Historic England

8 July 2016

**BUILDING 455 AND 457 HEYFORD PARK CAMP ROAD UPPER HEYFORD
Application No 16/01000/F**

Proposed demolition works (some of these works have already been completed as per planning permission 15/01944/F)

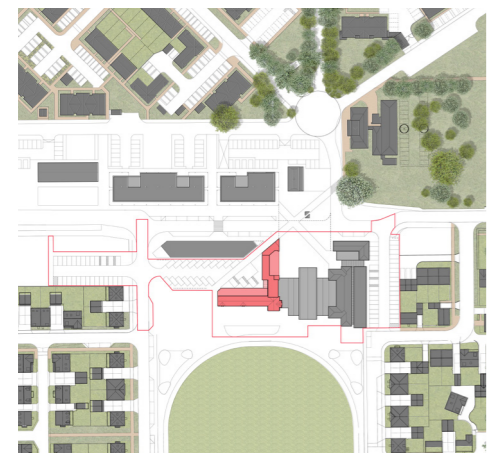
The current proposals are much more ambitious. The entire rear (northern) side of building 457 would be demolished and rebuilt, building 455 would be surrounded by new structures to the north and east and the two would be linked by a glass walled structure. This would make buildings 455 and 457 invisible when viewed from Camp Road. Consequently their visual relationship with the RAF buildings on the north side of the road, particularly 52 and 100, would be lost and the coherence of this road as a whole would be damaged. The Heritage Statement prepared in support of this application recognises that there would be a moderate degree of harm to the buildings. This in our view underestimates the harm entailed. Large areas of primary fabric would be lost and the way in which it is proposed to surround them with new building means that very little of their original context would survive. Consequently we conclude that there would be a high level of harm to the significance of the buildings themselves. Furthermore, the loss of coherence of Camp Road would result in a moderate level of harm to the significance of the conservation area as a whole, an issue not properly considered in the heritage statement.

Historic England recommend that this application is refused on the grounds that the harm entailed to the significance of buildings 455 and 457 would not be justified as required by paragraph 132 of the NPPF. We recommend that the extant planning permissions for the restoration of these buildings are implemented and less harmful ways of delivering a village centre are explored.
